Please find attached comments below on our agreed points and updated calculations and drawing.

For and on behalf of Cowan Consultancy Ltd.

Soakaway Test No. SA203 - Test 2
Contract: Yapton
Contract No. J20-043

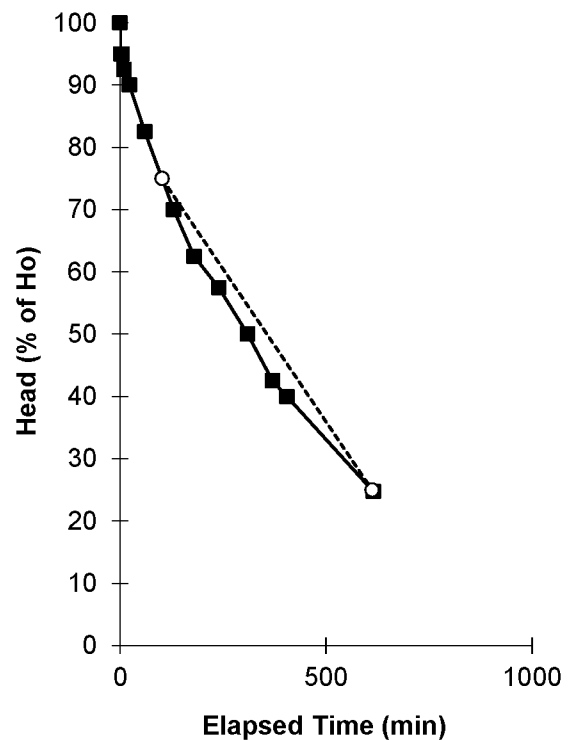
3. The calculations do not use the slowest infiltration rate for the site of $2.97 \times 10^{-6} \text{ m/s}$ (SA203). These will need to be adjusted irrespective of the outcome of points 2 and 3.

Calculations updated to use the minimum.

Title
Drainage GA

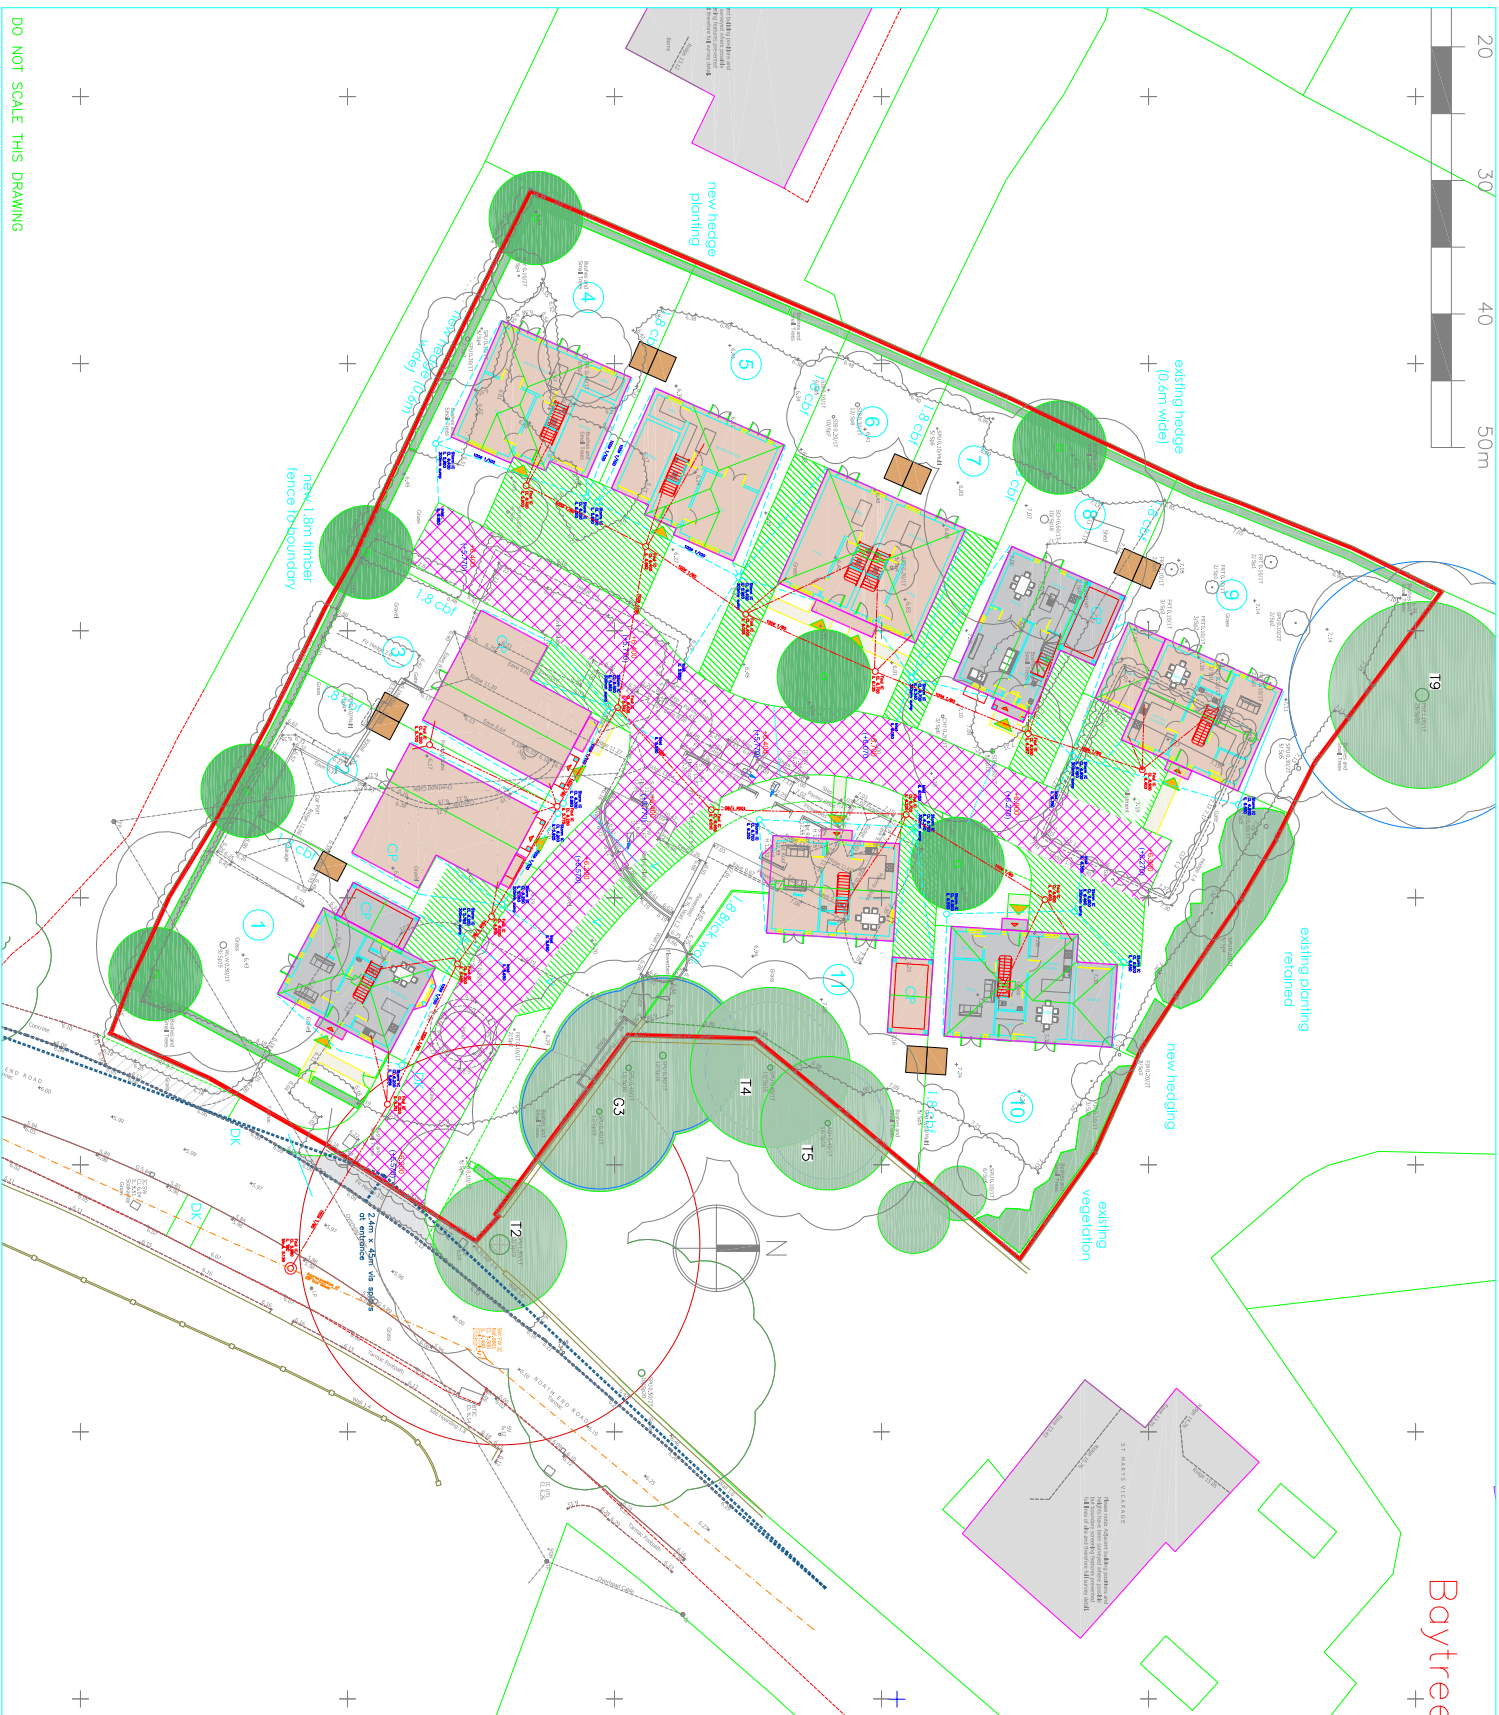
4. Please confirm that the calculations include the access road for the impermeable area. They state 'car park + driveway + roofs', the same is stated for the permeable car parking areas. Please supply an impermeable area plan as per the Drainage Checklist.

Yes all hardstandings have been included to the calculations including the access road. The drained areas are as the noted hatched areas on my drainage GA attached.
